Transport
for NSW

TfNSW Reference: SYD21/00574/04

DPIE Reference: SSD-18204994

**EXHIBITION OF EIS - EXHIBITION OF EIS - SNACK BRANDS MANUFACTURING
FACILITY - 14 & 2 DISTRIBUTION DRIVE, ORCHARD HILLS**

ENTRY (B-DOUBLES)

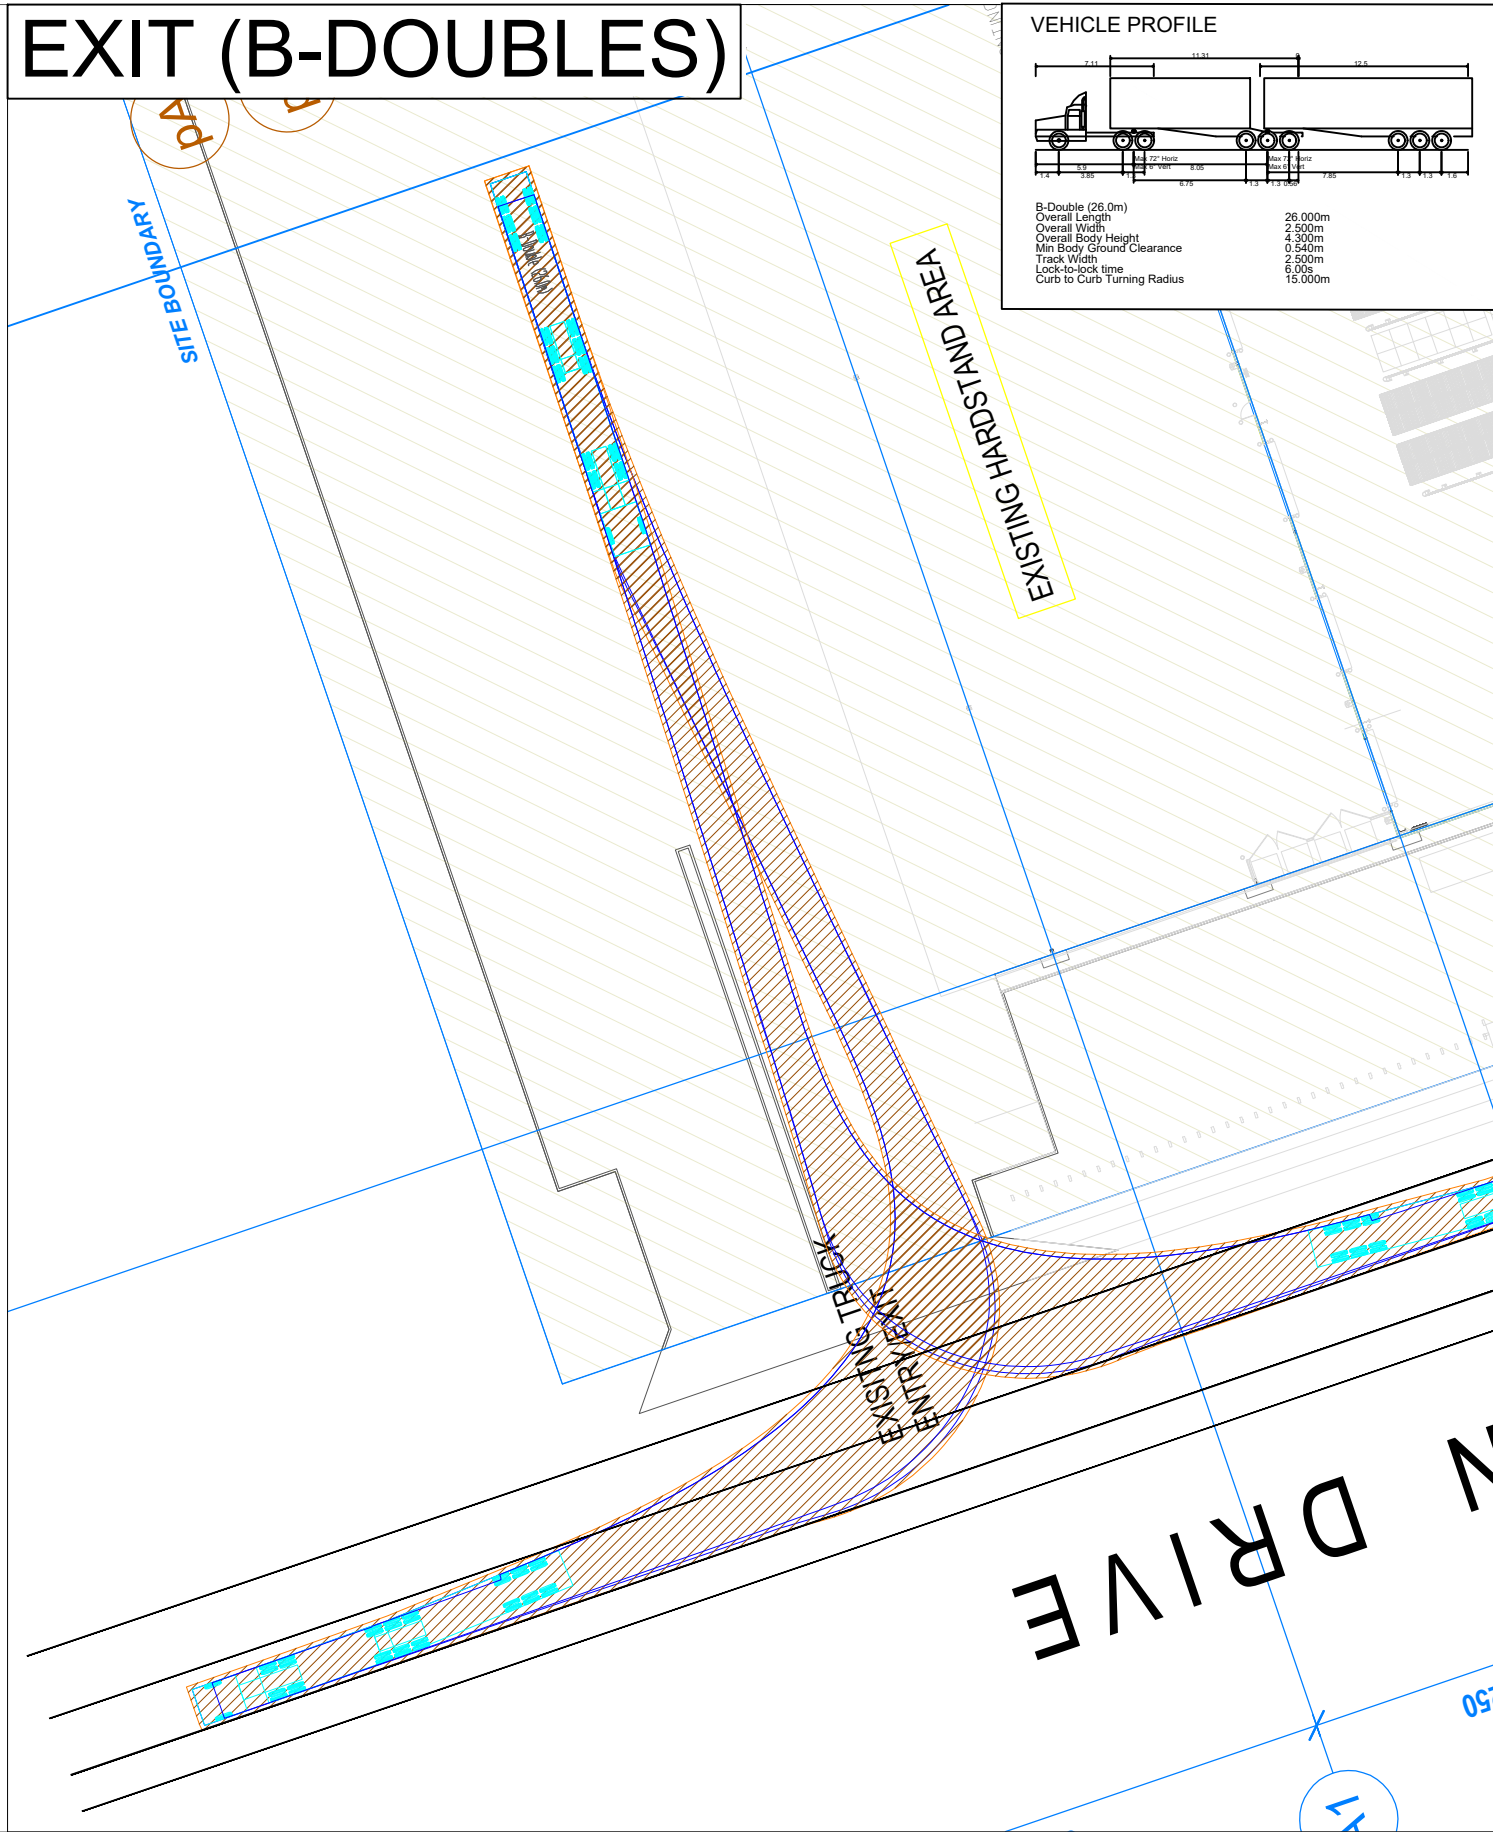
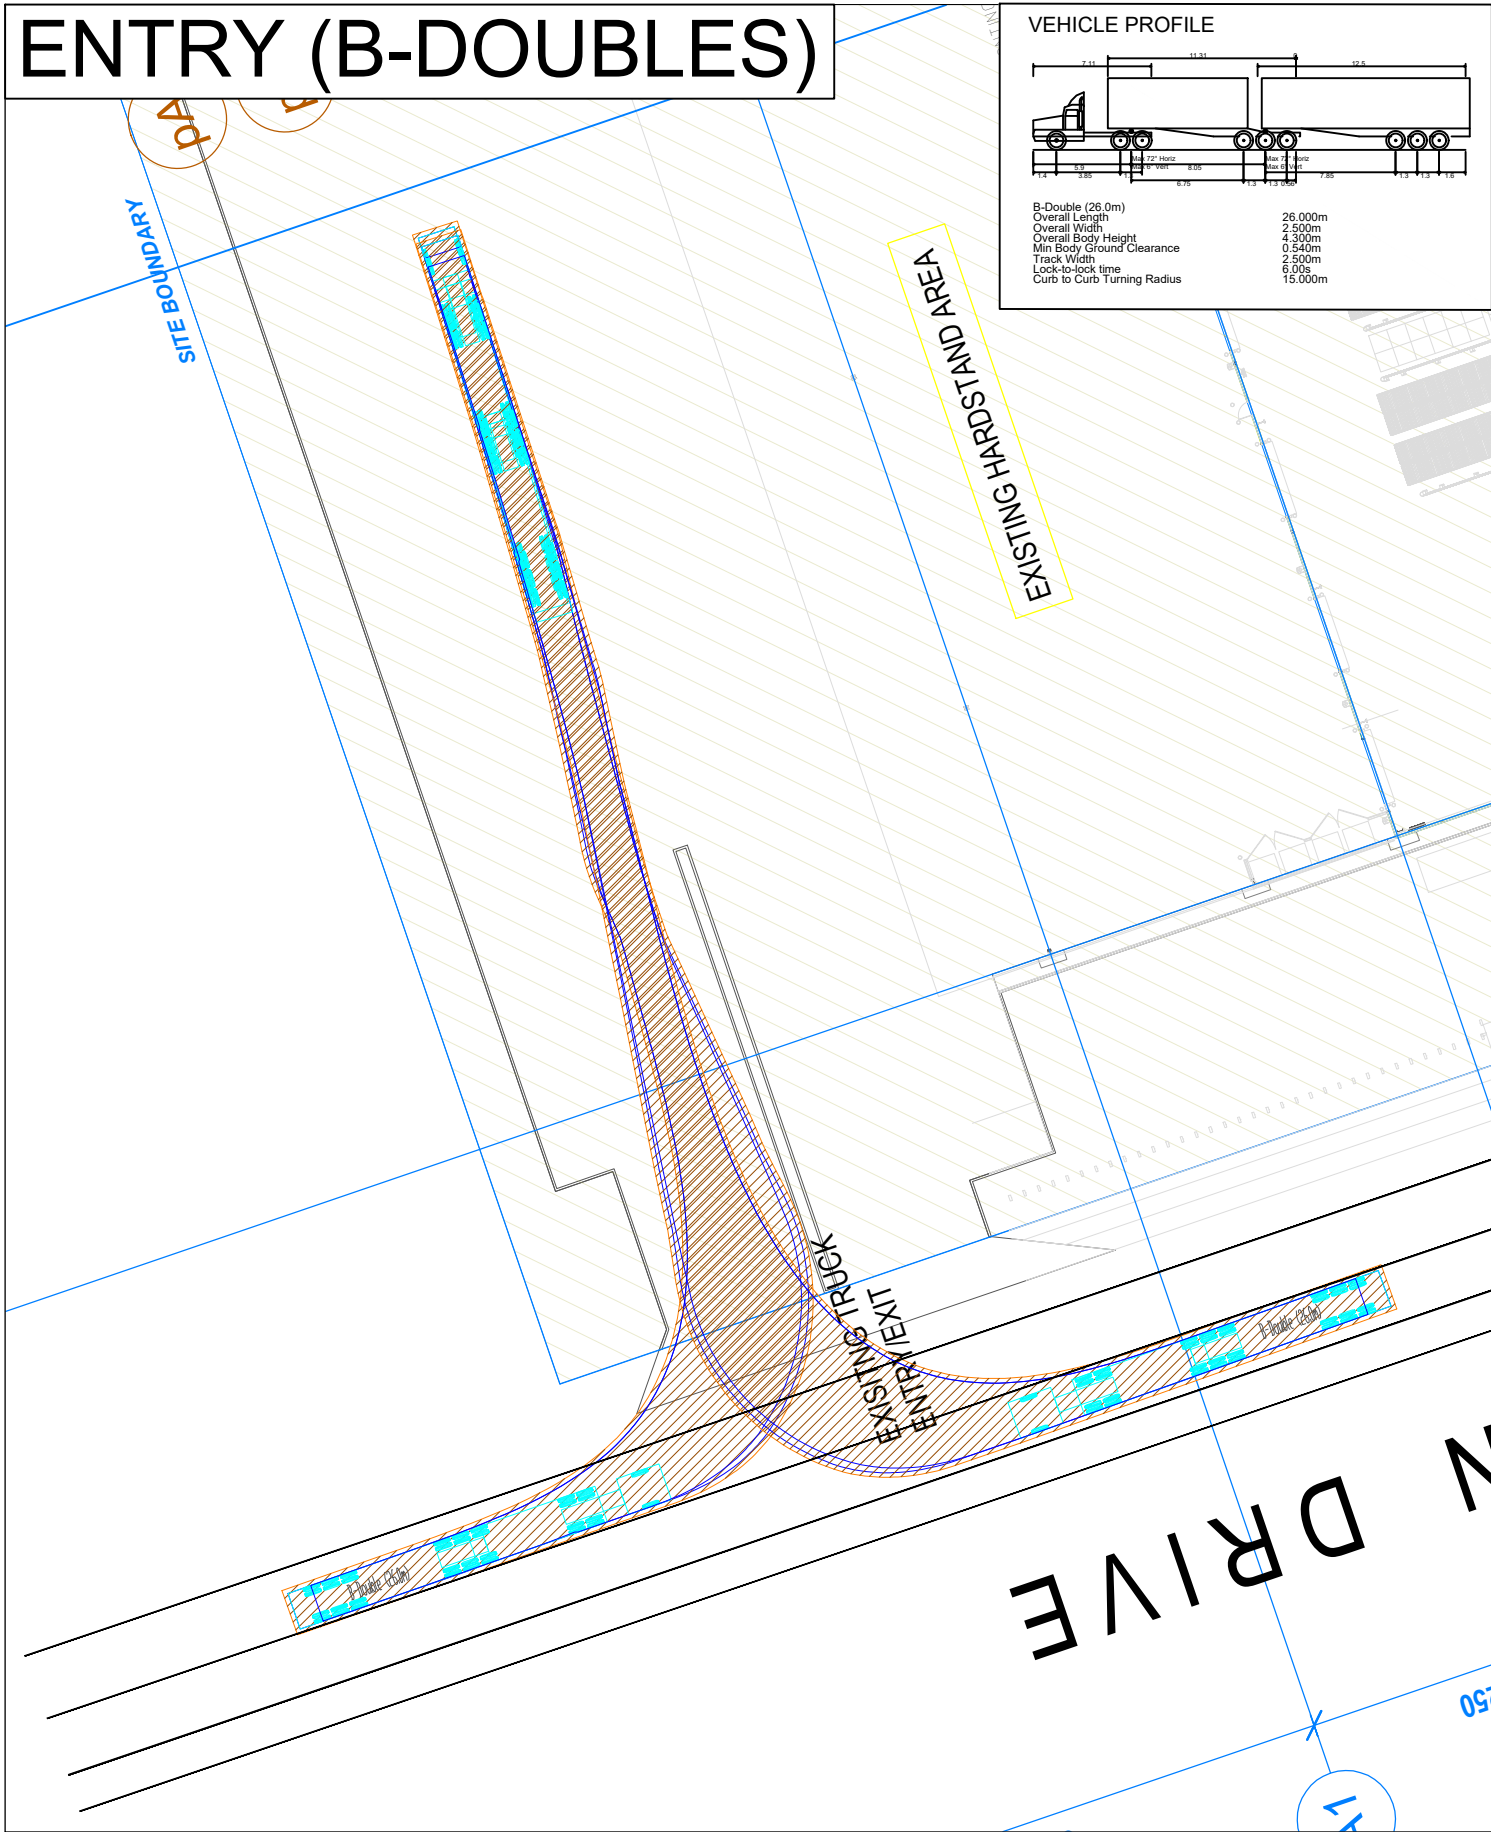
Mamre Road is an approved PBS 2B route and large industrial development within Western Sydney Employment Area should consider PBS 2B as the design vehicle. However, the Transport Assessment (TA) site accesses and internal hardstand areas have been designed to cater for trucks of up to 26.0 metres B-doubles.

The TA needs to graphically demonstrate site accesses and internal hardstand areas have been designed to cater for trucks of up to a 30m PBS Level 2B vehicle.
